Re: Hsiao Short Plat – *Technical Review 1*  
SP22-004

RE: Hsiao Short Plat, File# SP22-004  
Preliminary Short Subdivision of 1.14 acres into five (5) single-family detached lots  
4100 81<sup>st</sup> Place NE & Parcel # 00550600001200, 00550600001300, 30052100314700

SECTION 'A-A'
81ST PL NE
LOCAL ACCESS STREET
RESIDENTIAL
DESIGN SPEED = 25 MPH
N.T.S.

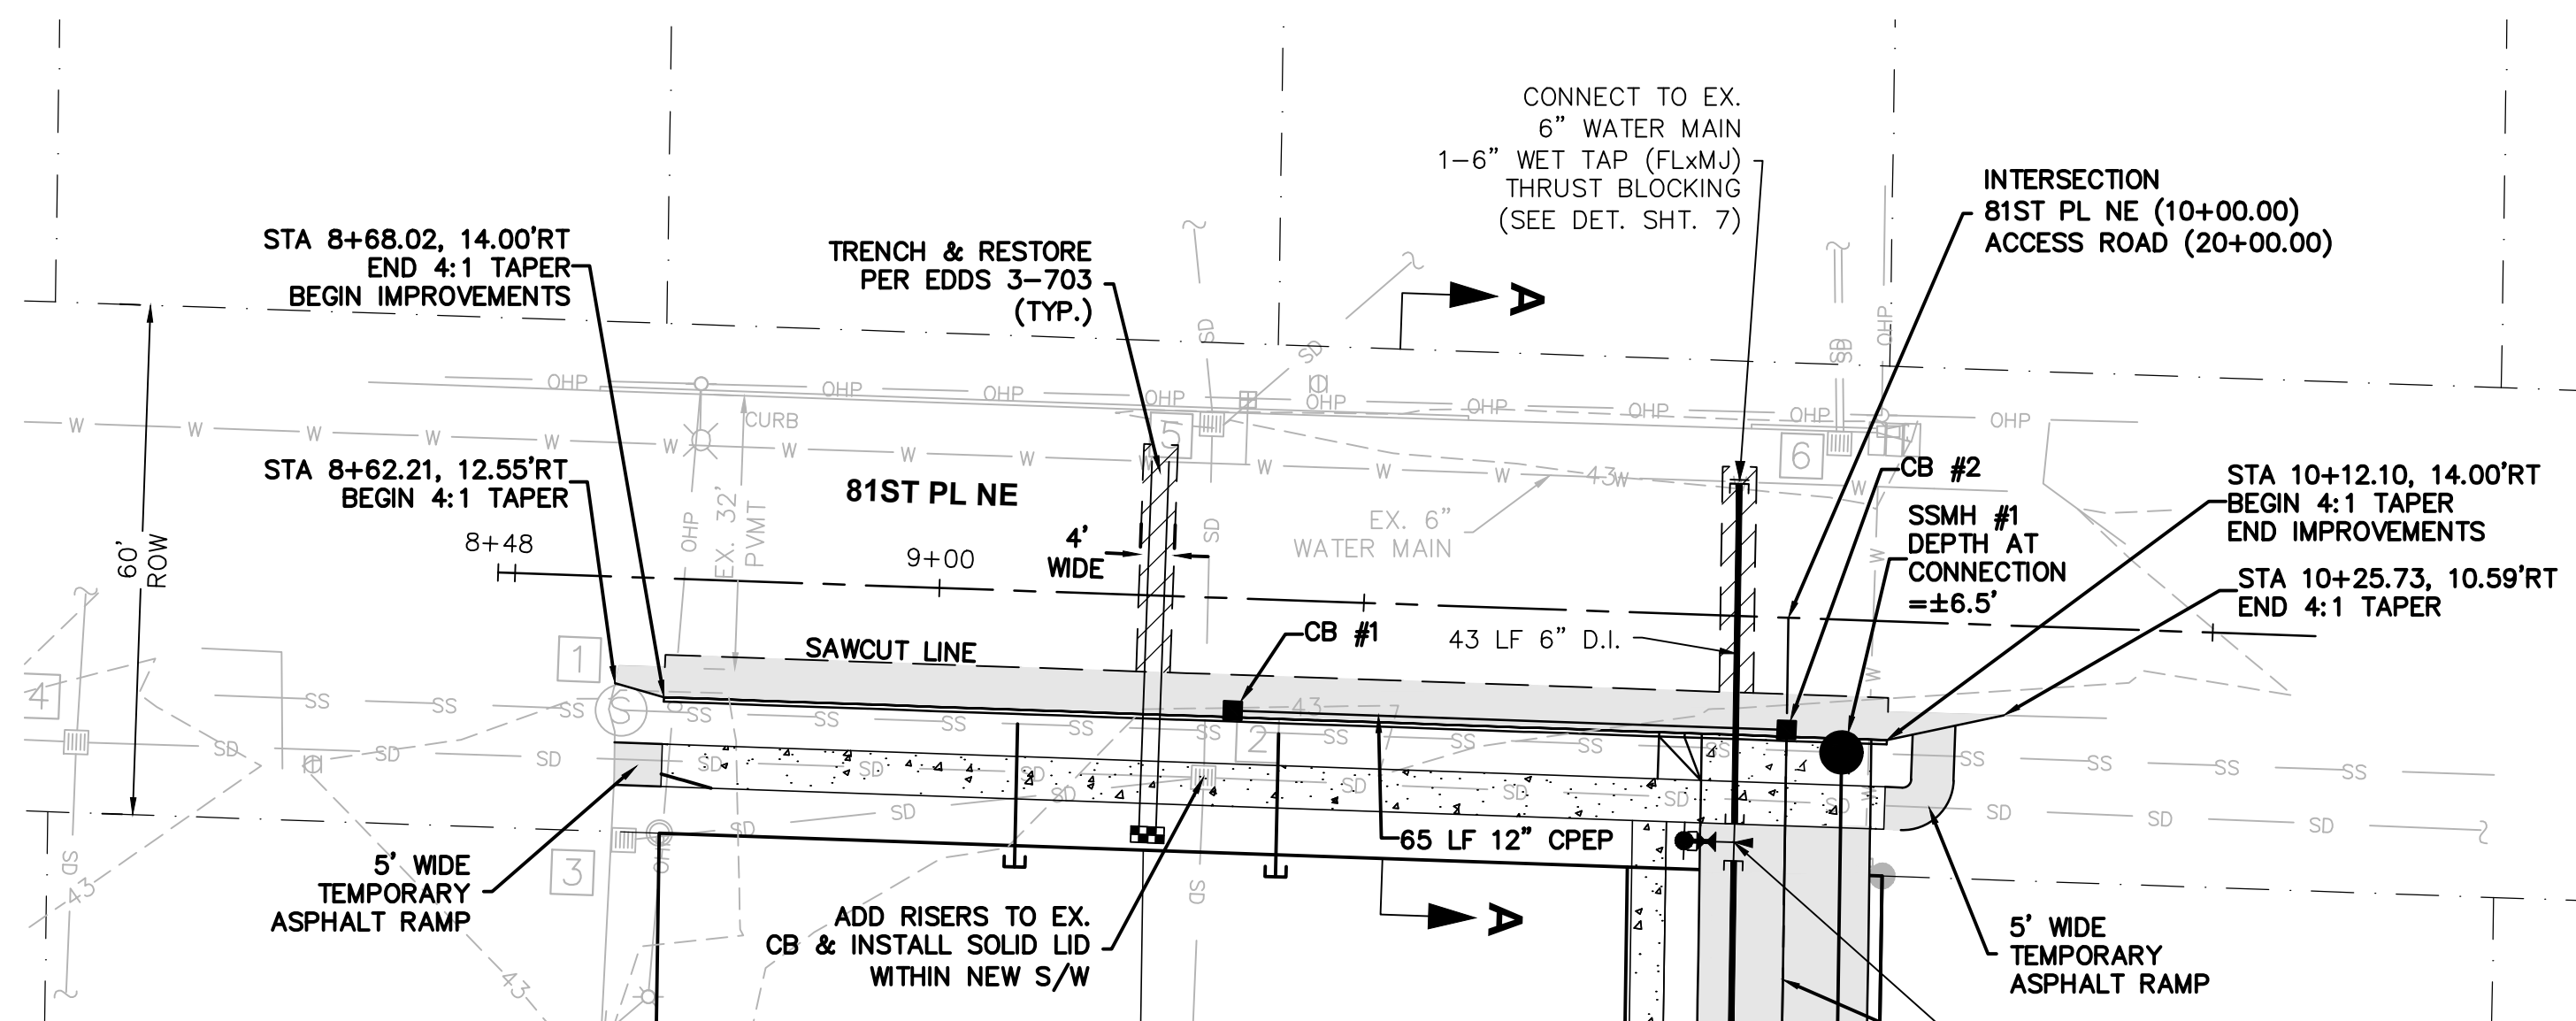
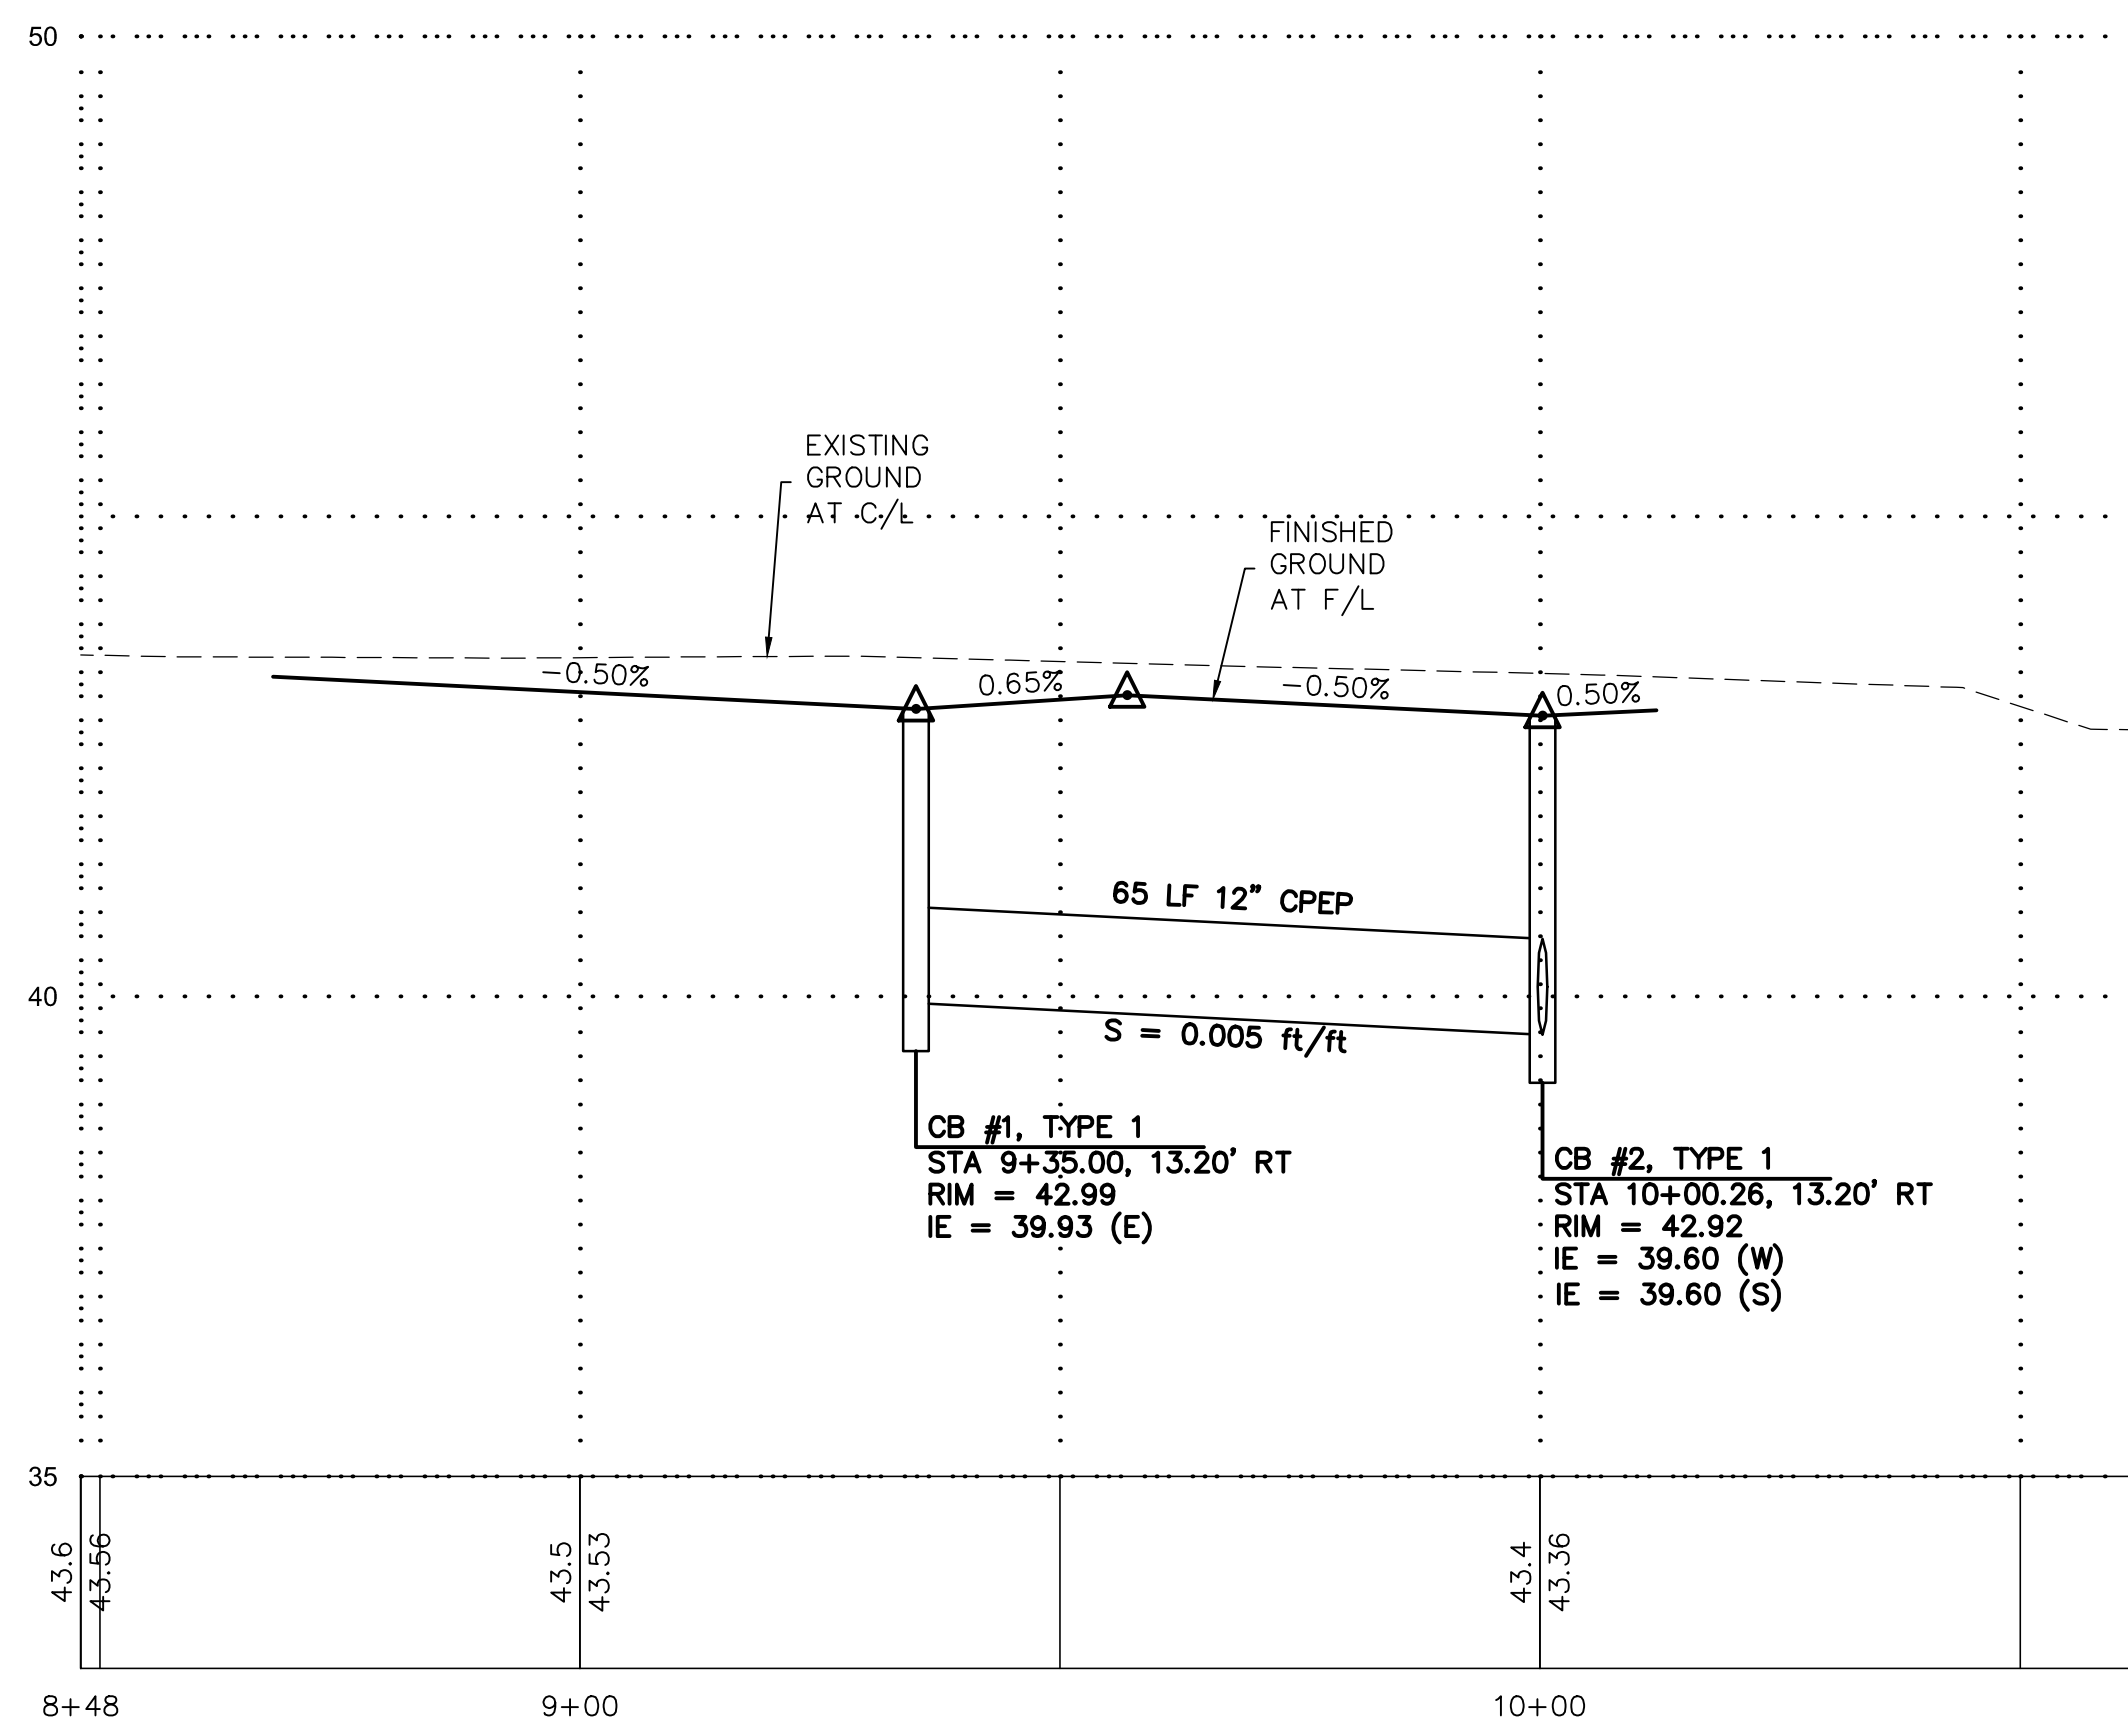
- 3) 81<sup>st</sup> PL NE Frontage improvements:
  - a. Roadway frontage improvements shall be constructed per 50' ROW residential street cross-section.

- 4) Undergrounding of overhead utilities shall be required upon frontage.
- 5) Per EDDS 3-506, street lighting will be required.
  - a. Street Lighting upon 55<sup>th</sup> Ave NE shall be PUD installed fiberglass pole installation type street lighting.
